Application No: MP07_0158 MOD 3

**Modification Request for the University of Sydney Abercrombie Precinct
Redevelopment**

Ground Floor Plan
1:200@A1
11.10.13
4001_DA02-D

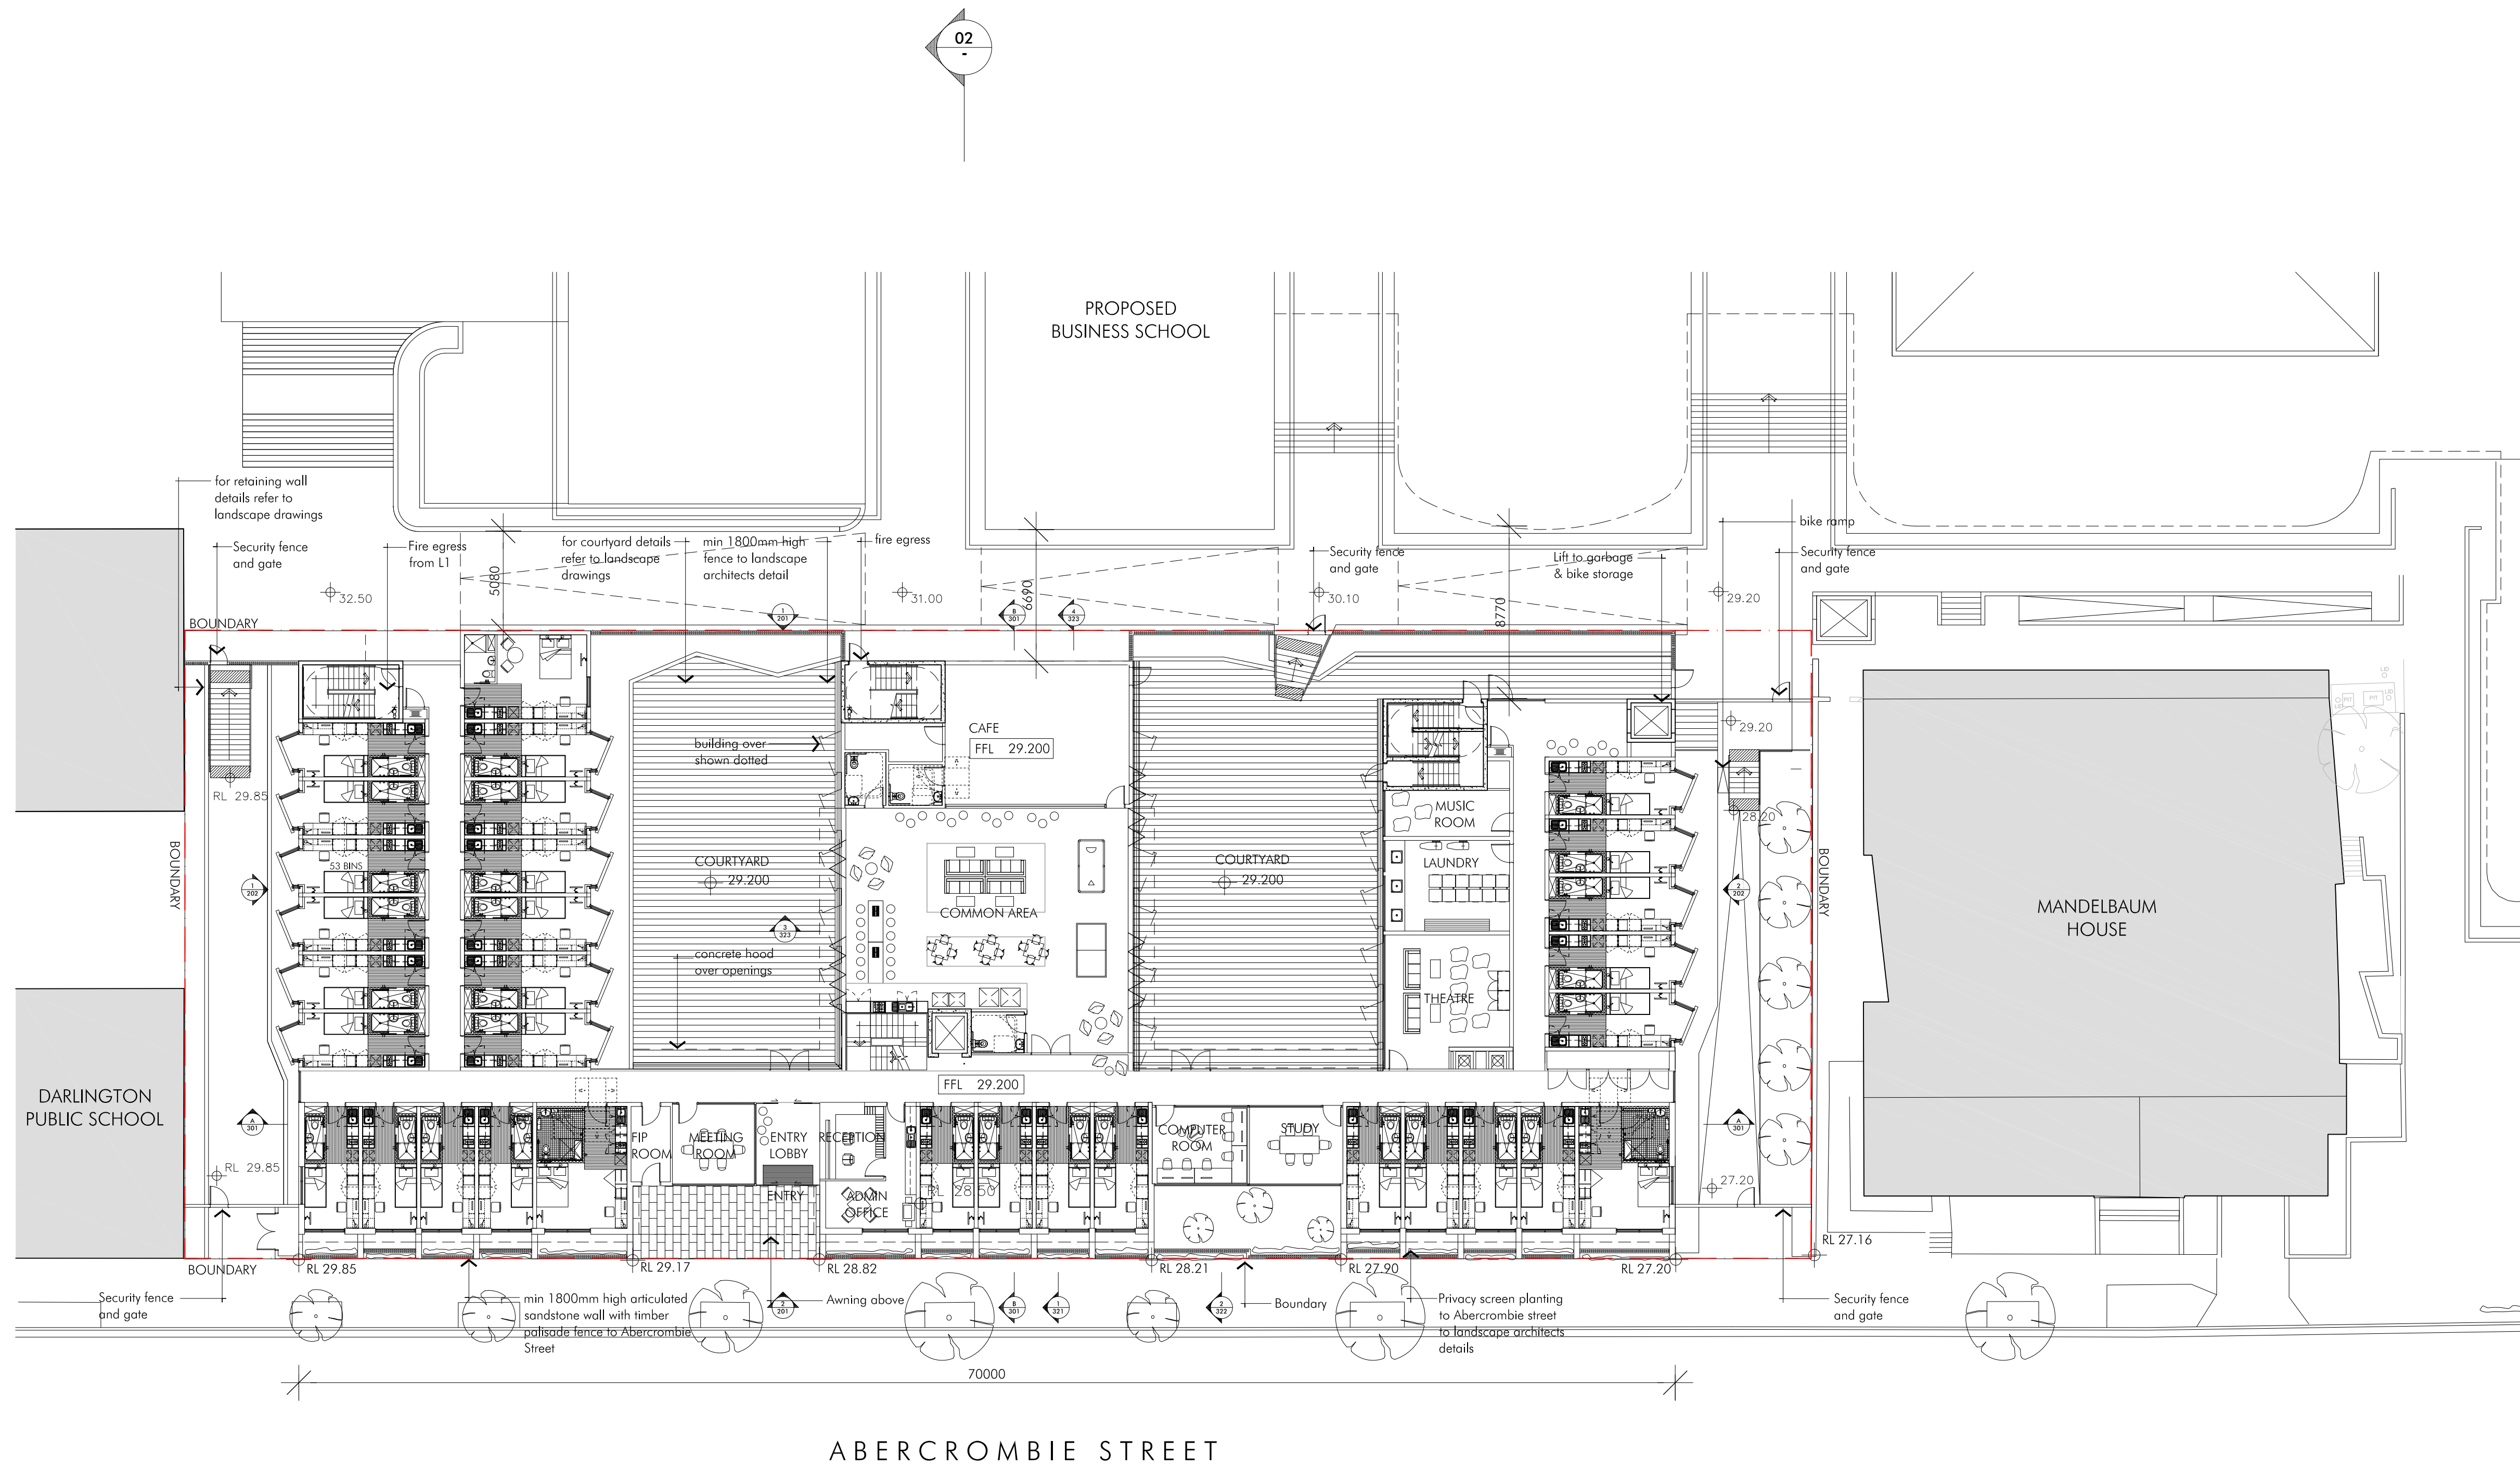
2. The University's original plans had the building sensibly set back from the street. The setback reflected the setback of other residential buildings in the street, including Mandelbaum House. The setback would afford both students living in the development and residents living opposite adequate privacy, particularly since the setback would allow for more extensive vegetation screening.
[Therefore, we object to the University's modification request to move the front of the building closer Abercrombie Street.](#)

01 ELEVATION NORTH
SCALE 1:200

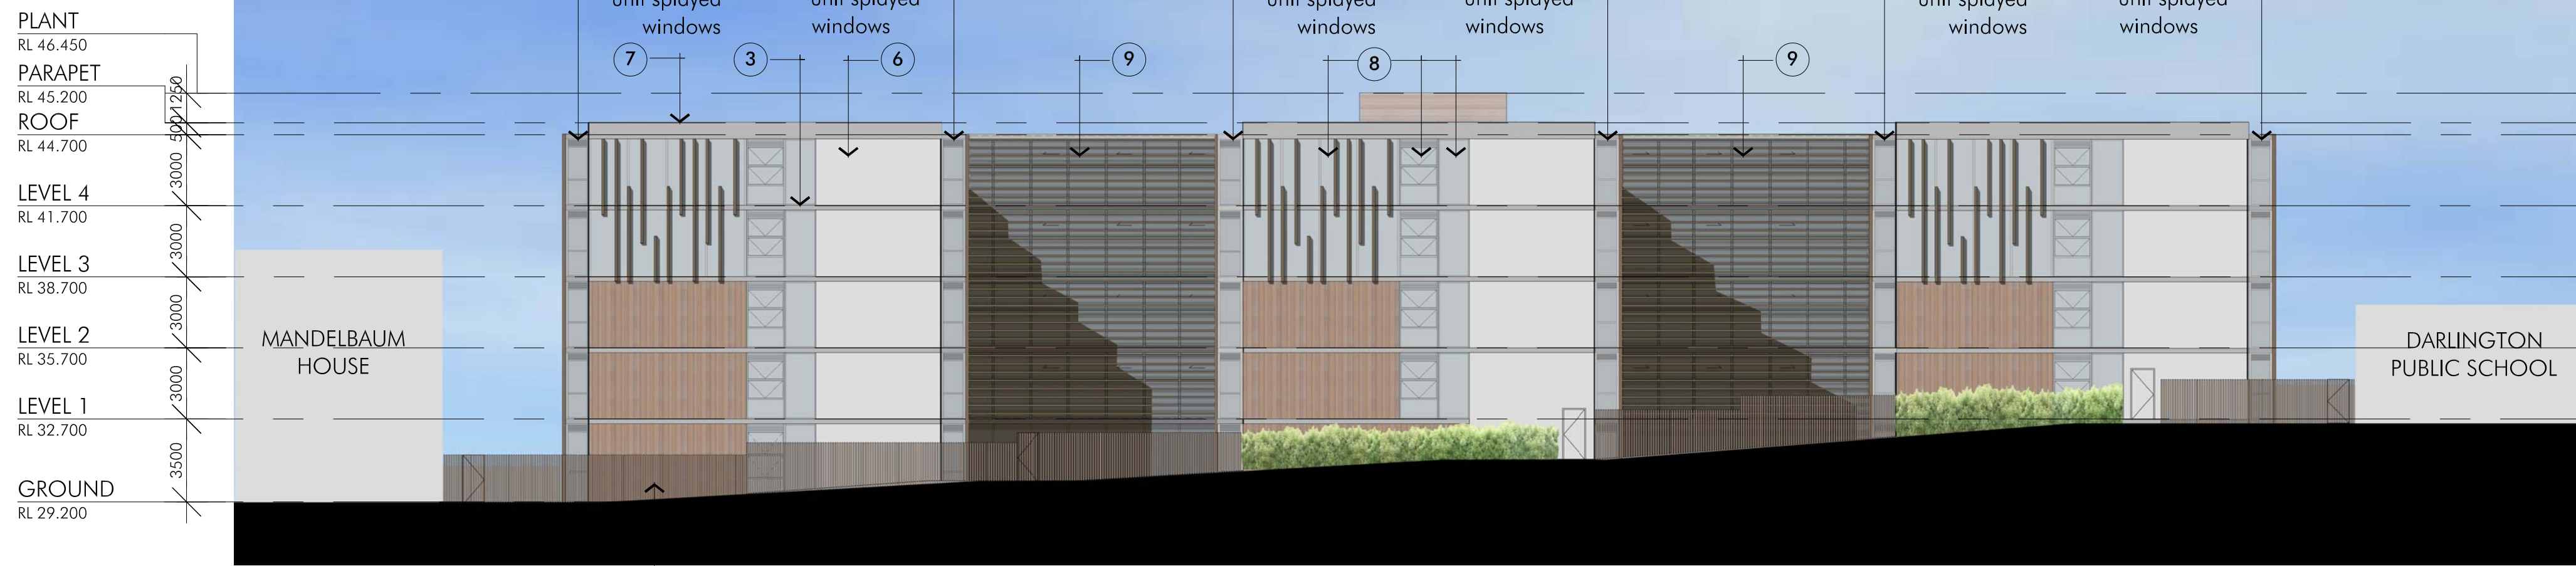
Also, we object to a deceptive artist's rendition of the development issued by the University which shows the 5 storey student accommodation building as being barely higher than the 2 storey neighbouring primary school (see below).
